Development Management Committee
2 March 2017

WELWYN HATFIELD COUNCIL

135. 11 BROOKMANS AVENUE, BROOKMANS PARK, HATFIELD, AL9 7QH - 6/2016/1778/FULL - ERECTION OF REPLACEMENT BUILDING CONTAINING 5 FLATS WITH FORECOURT PARKING FOLLOWING DEMOLITION OF EXISTING HOUSE:

Org.No. 419814/7 Rev.

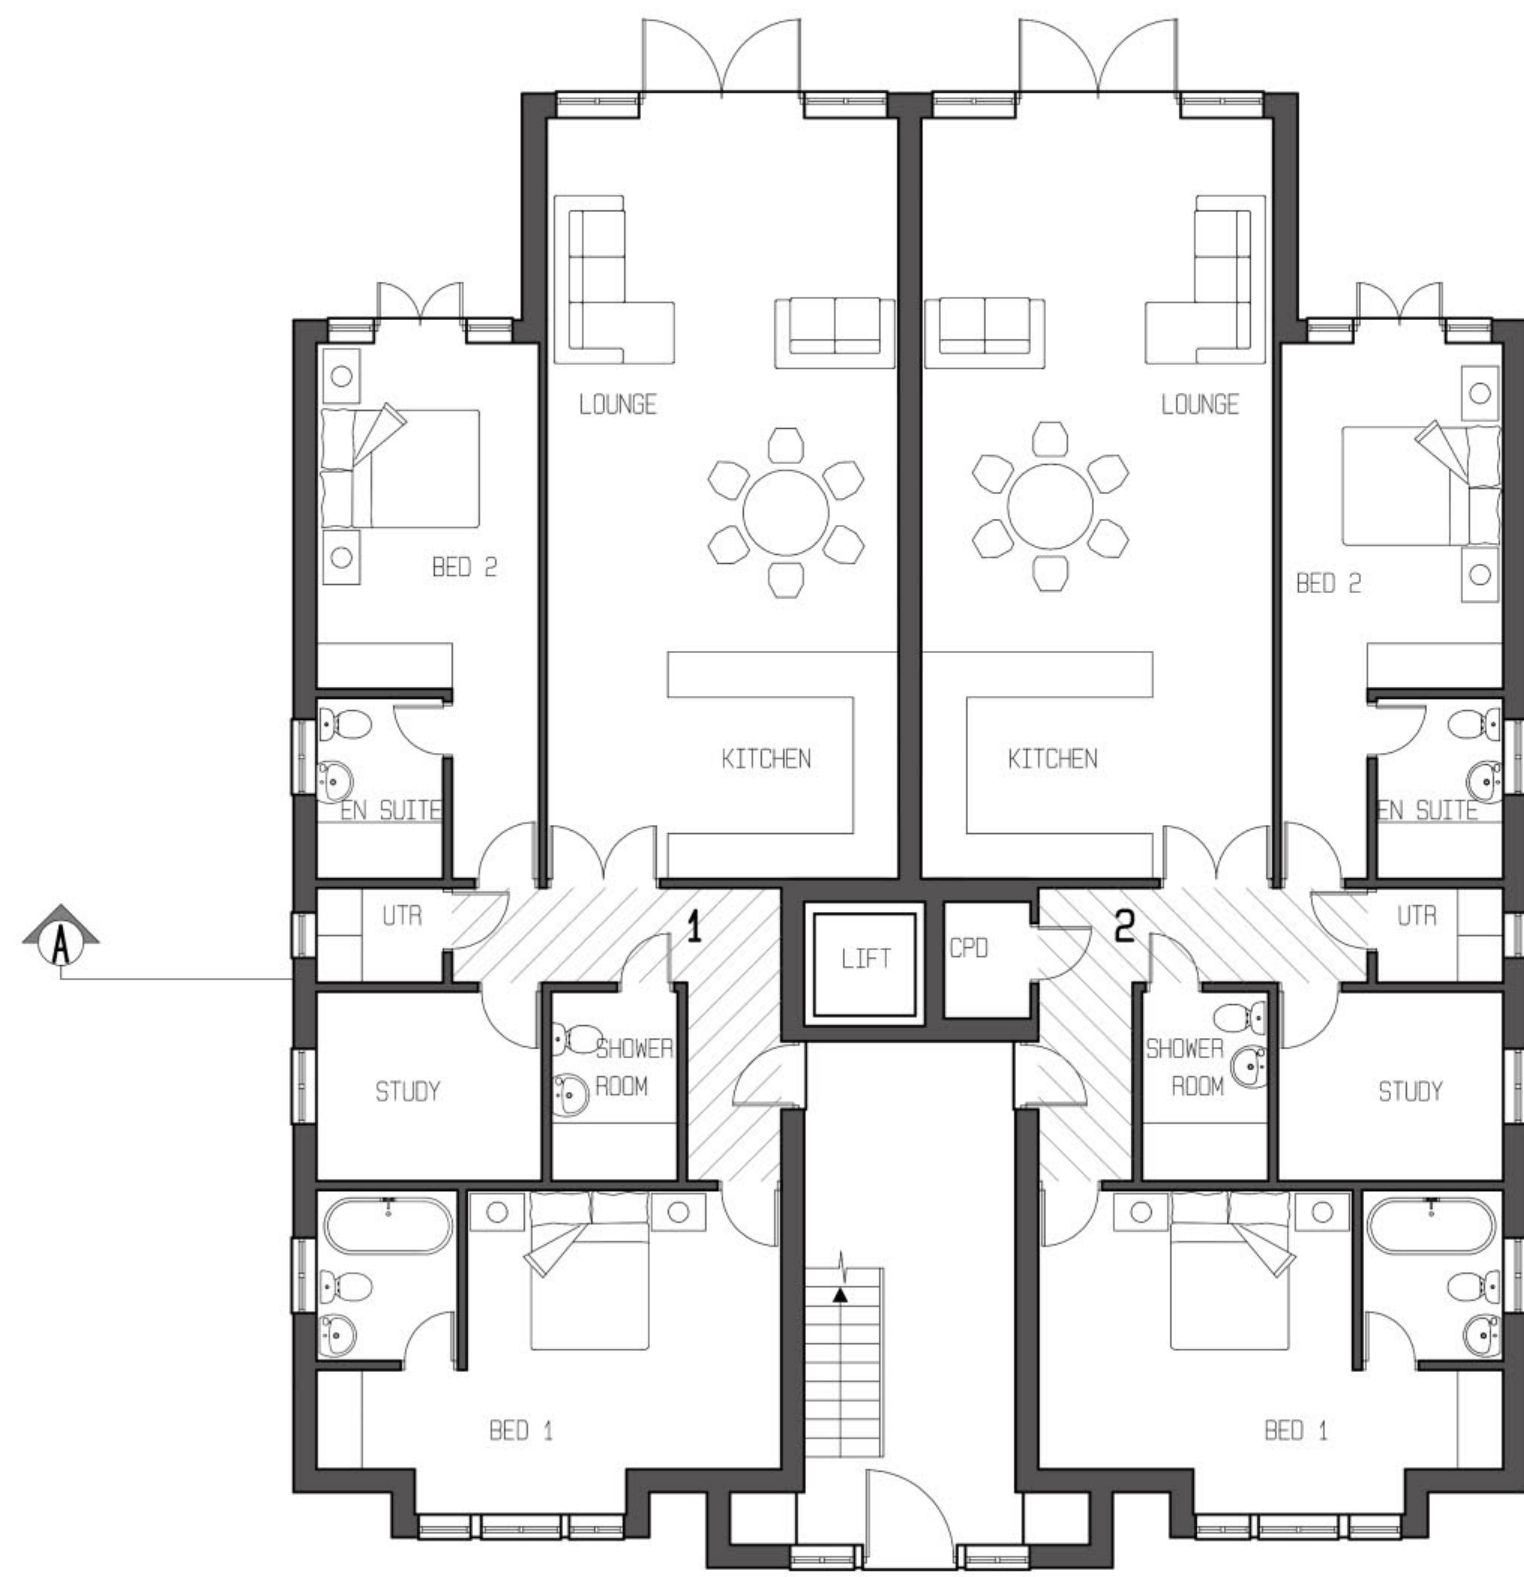
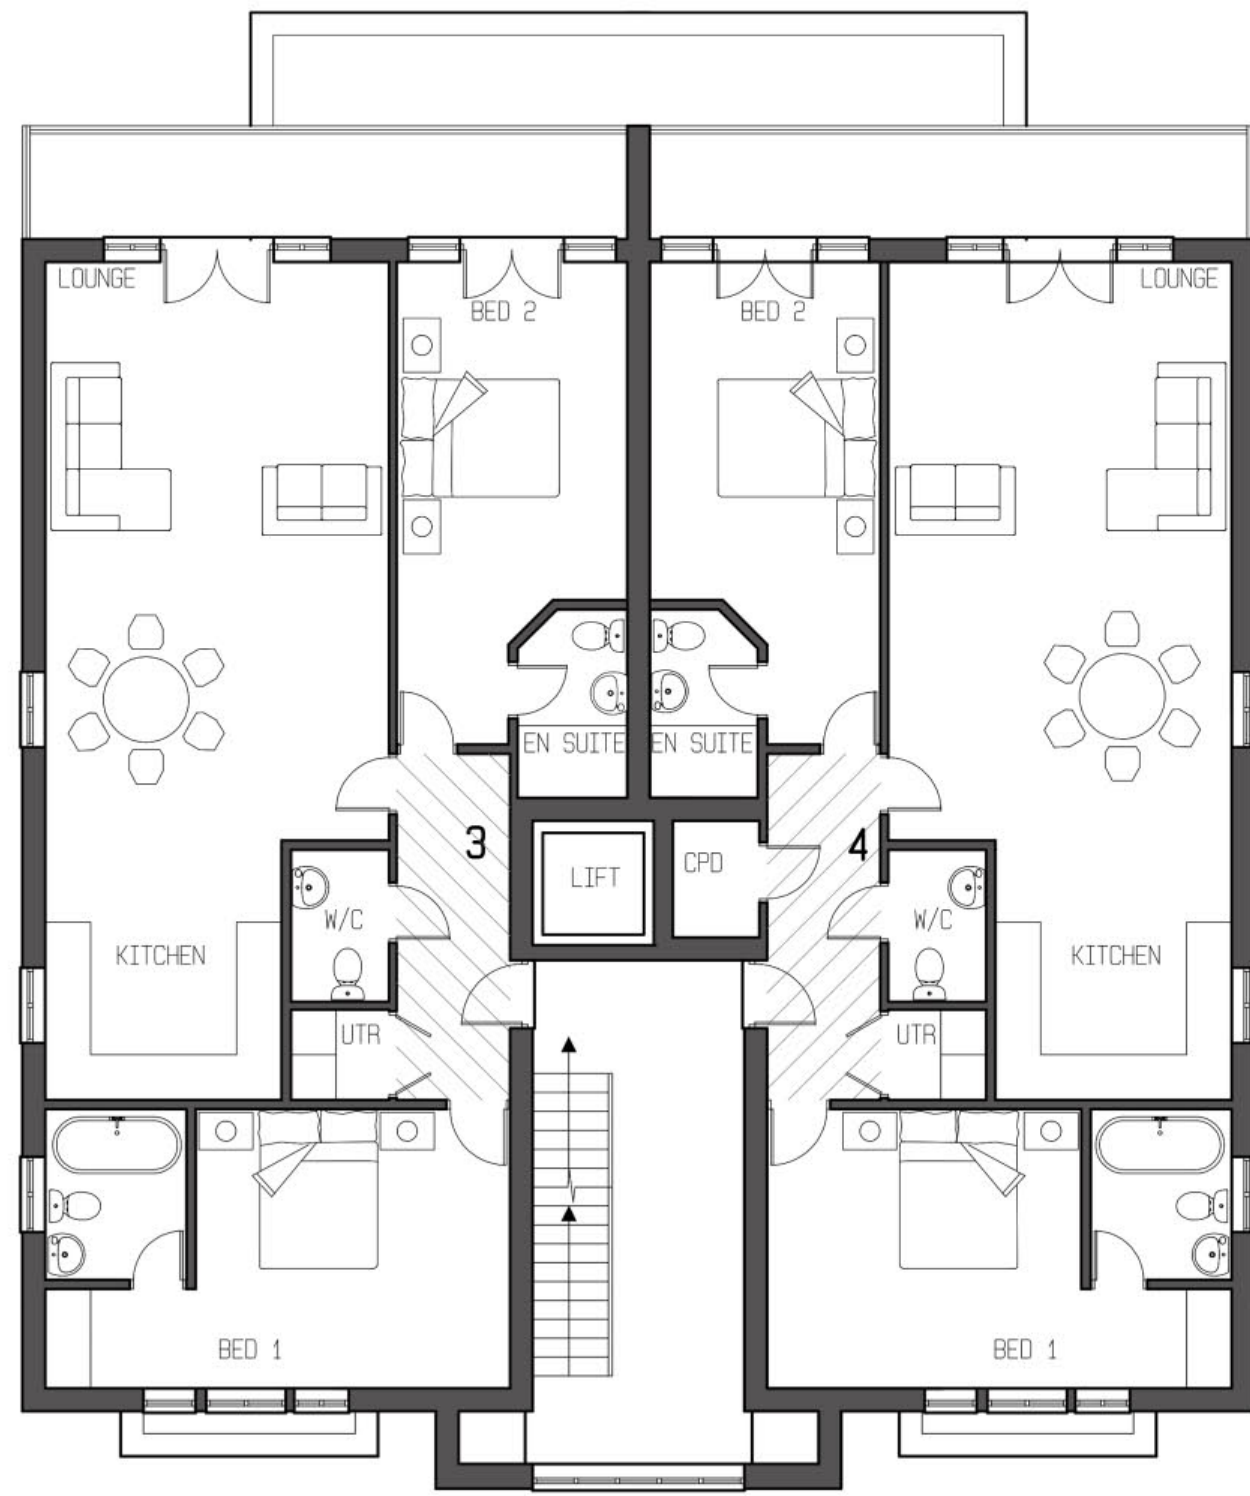
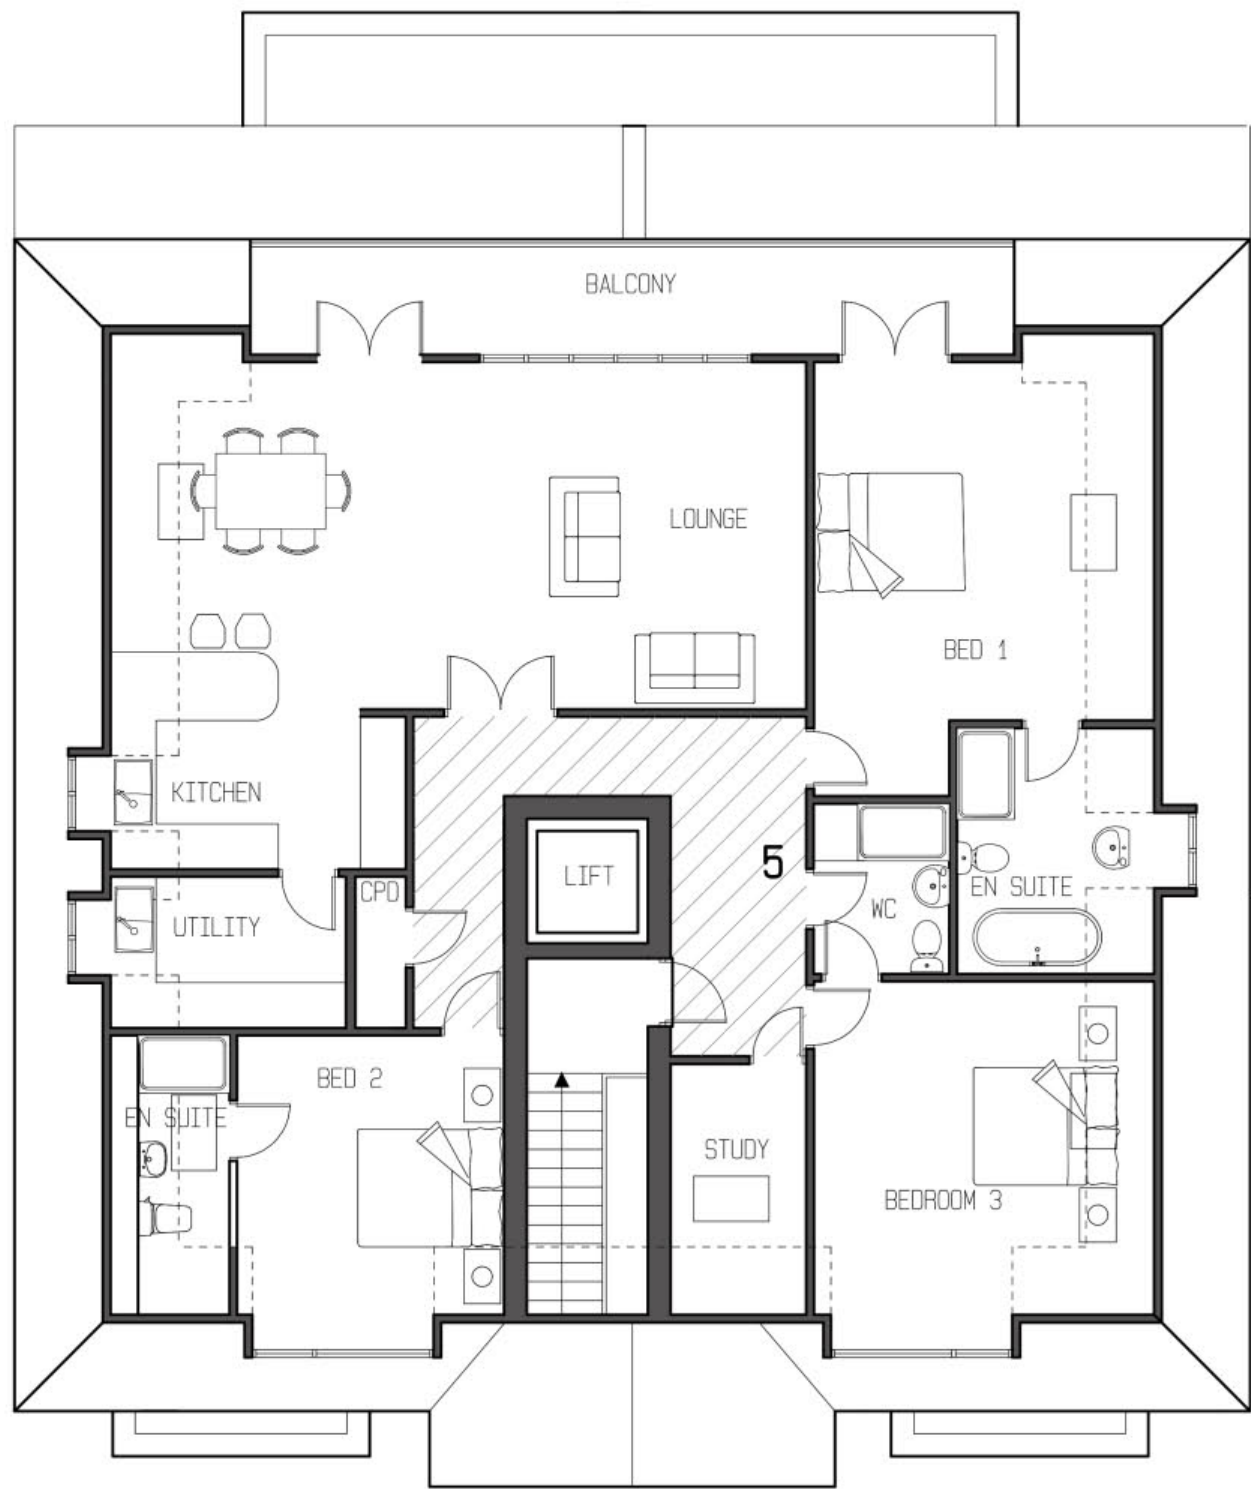
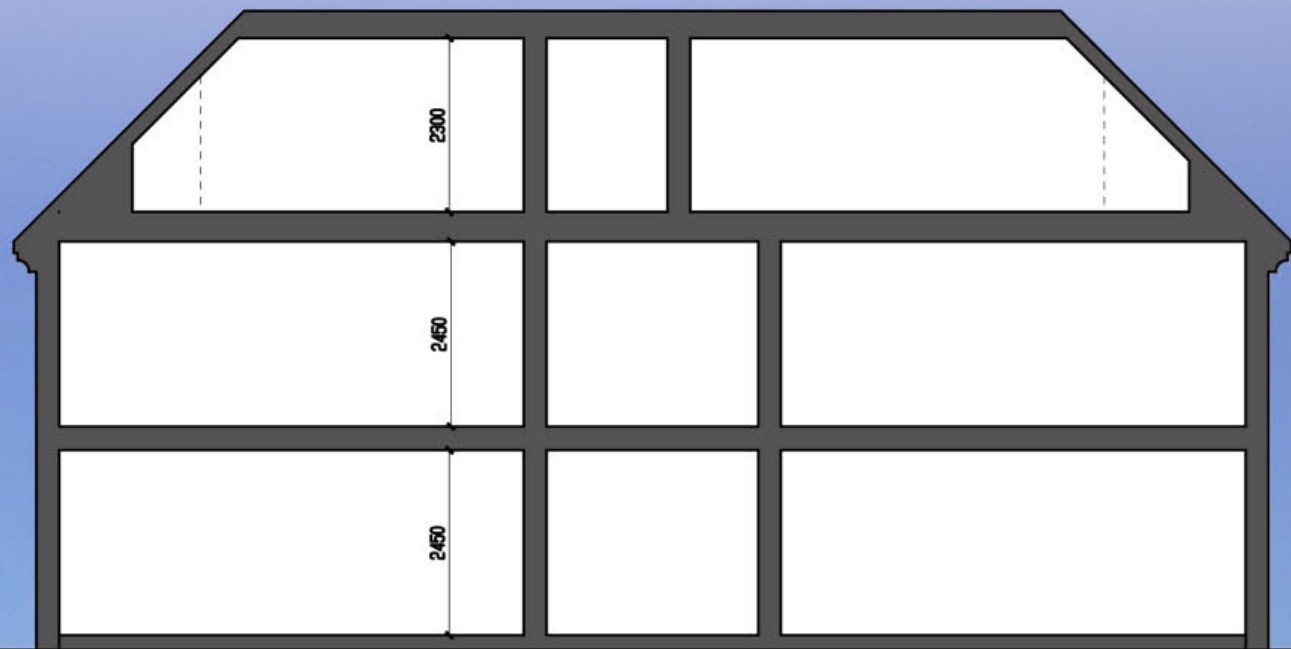
- Three flats were sufficient for the site and location.
- The proposal of five flats was considered to be an excessive mass with inadequate parking which was below the Council's parking standard.

- It was understood that one of the adjoining properties had also applied for planning permission for flats.
- The dormer windows contained in the roof slope would be out of keeping with the character of the area and would not be compatible with the street scene.

- The existing property had two stories with no dormers. The proposed development had front dormers. There were no dormer windows in Brookmans Avenue.
- Currently there were no flats in the road only at gateways on corners.

With regards to the decision of the Planning Inspectorate (APP/C1950/#W/15/3128952) the increase in the number of flats from the permitted three to five represents over development of the site. Insufficient parking would be provided in an area where there is a high parking demand. The proposal fails to respect and relate to the character and context of the locality and would have a material and harmful effect contrary to saved Policies GBSP2 and D2 of the Welwyn Hatfield District Plan 2005 and the National Planning Policy Framework.

Org.No. 419814/8 **Rev.** A

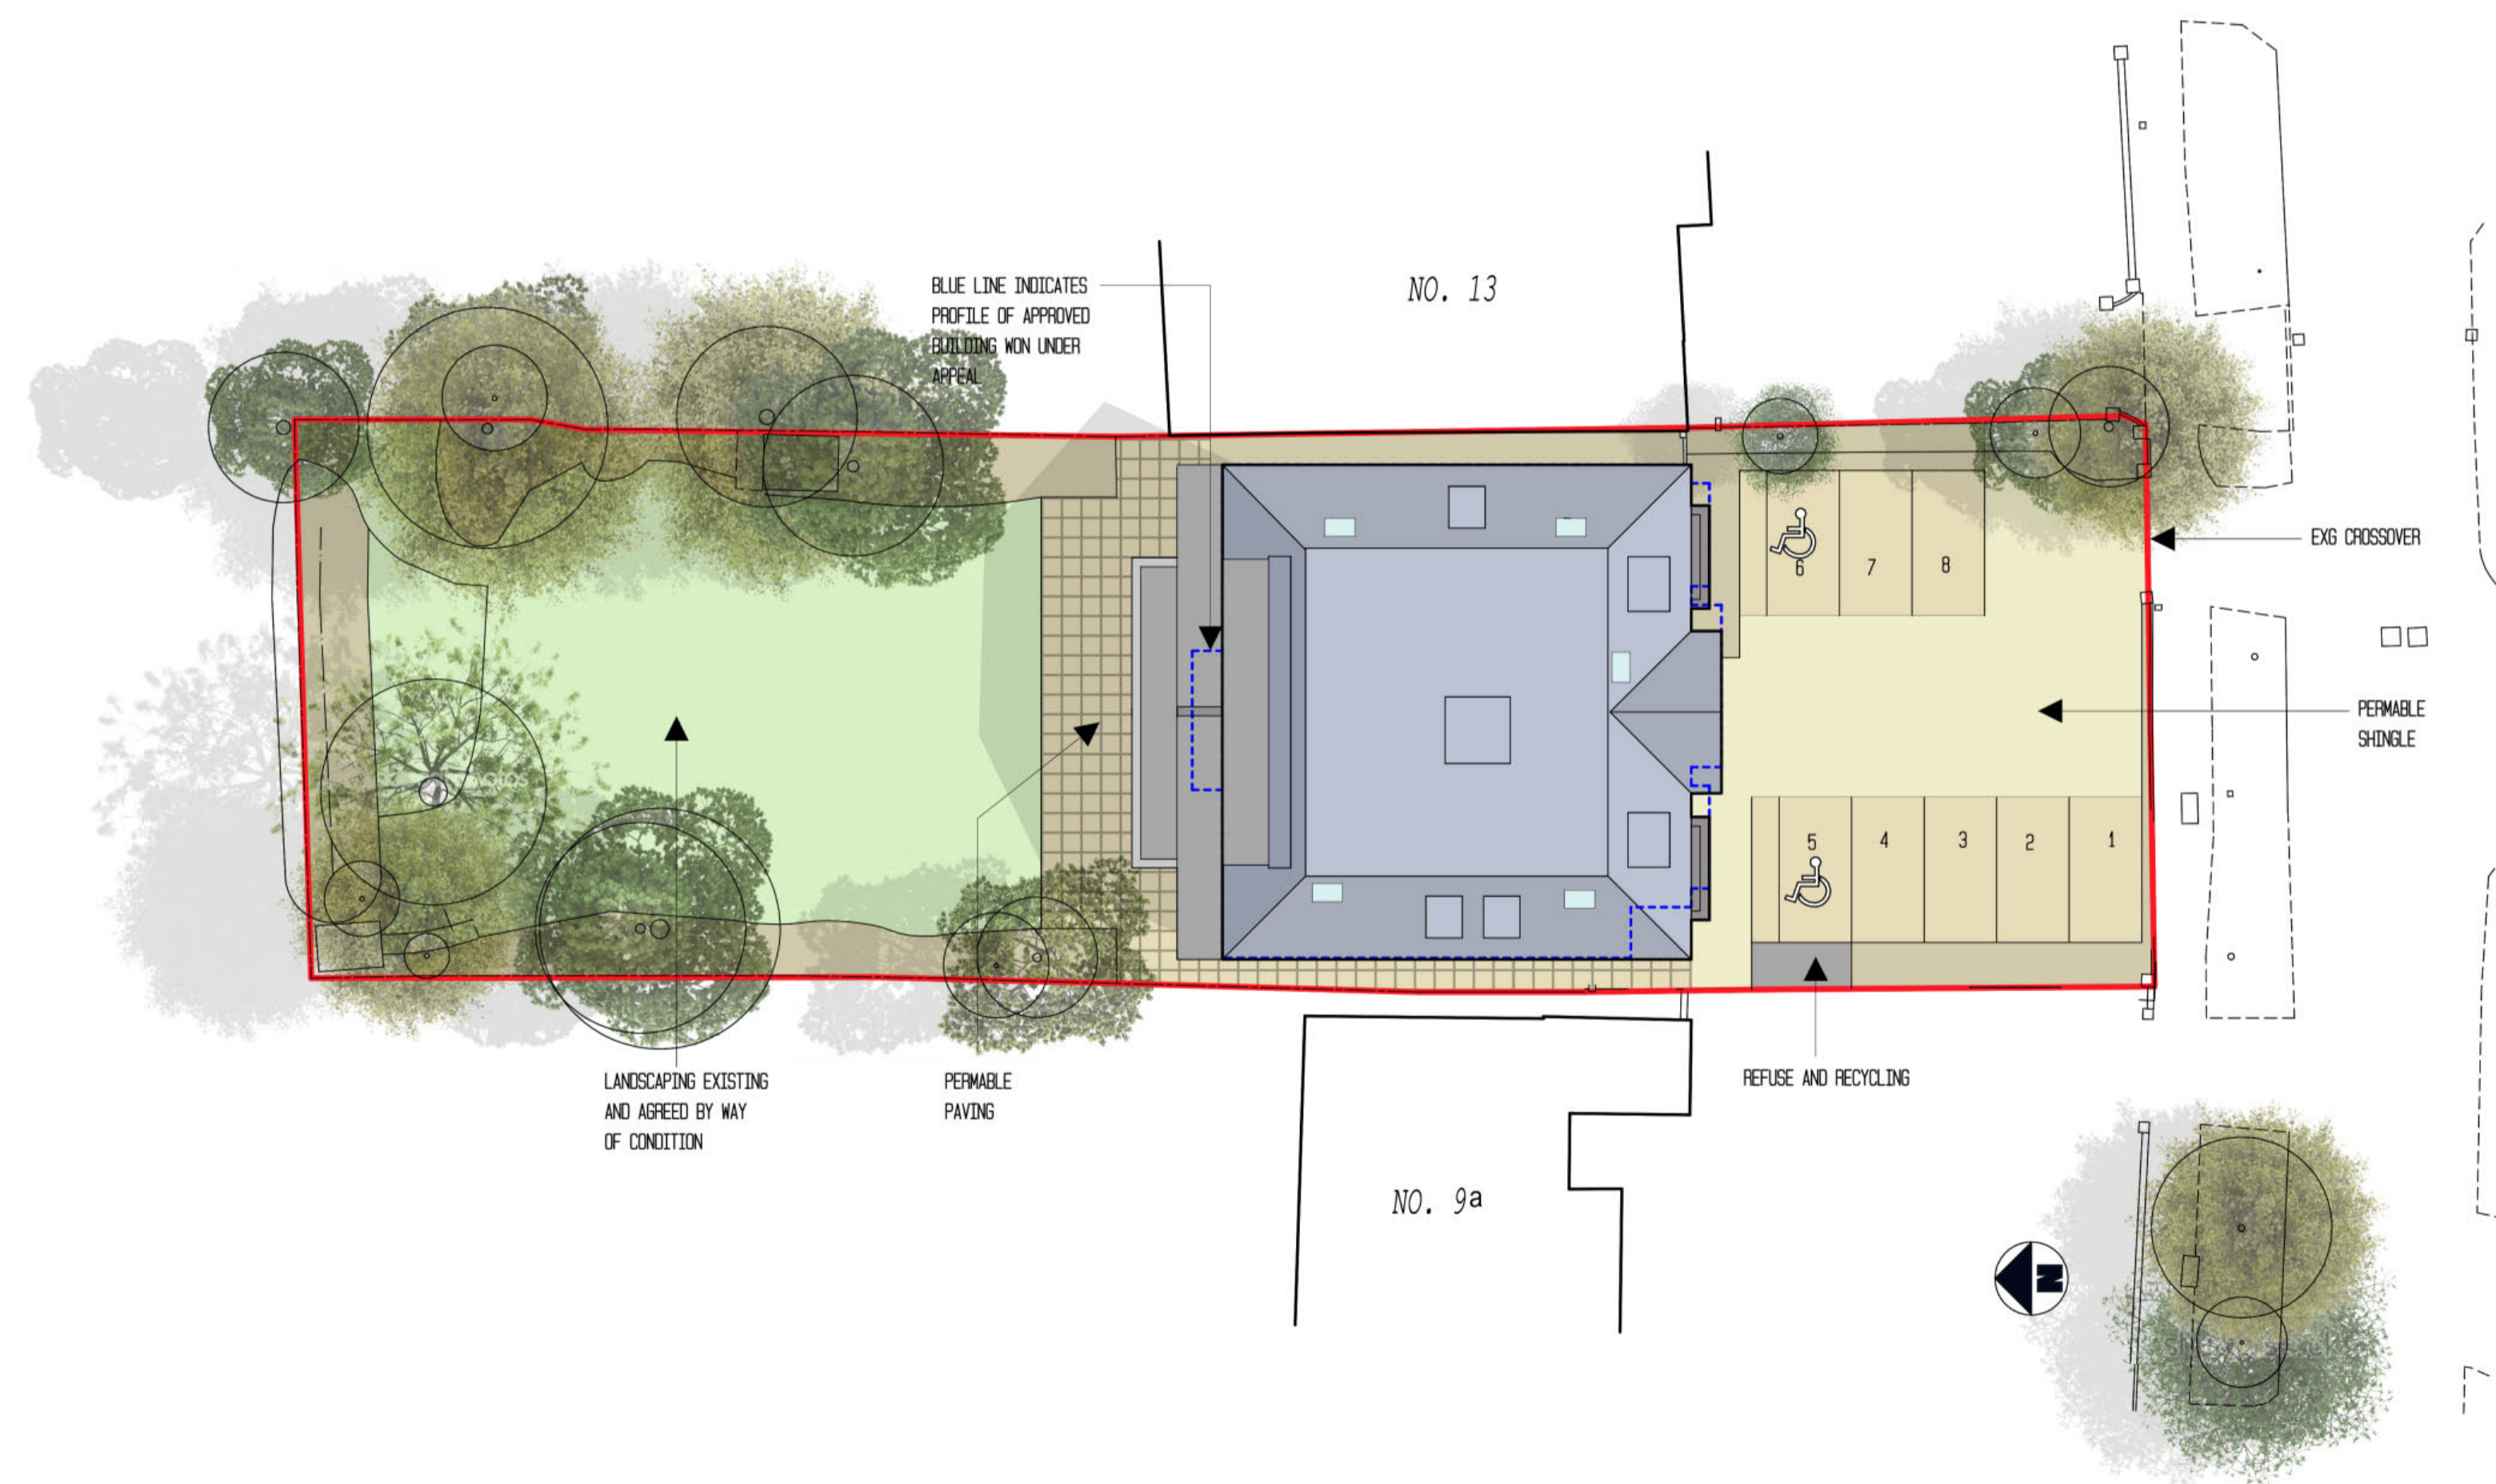
- All vehicles would enter and leave the site via the existing vehicular access in Brookmans Avenue, an already very busy road with parked cars.
- The proposal would not alleviate the parking issues currently experienced by local residents.
- The assumption had to be made that, due to the price of each individual flat, there would be two cars per flat despite its close proximity to the railway station. The purchasers of the properties would be independently minded and would therefore, in their view, require a car each.
- The proposal to provide spaces for eight cars/vehicles to park within the site was inadequate for the proposed increase in flats.

- The number of car parking spaces was below the Council's minimum standard.
- The additional vehicles parking on Brookmans Avenue would cause increased congestion. Problems were already experienced with regards to parking for the shops, which already backed-up on Brookmans Avenue and the proposed development would exacerbate the current situation.
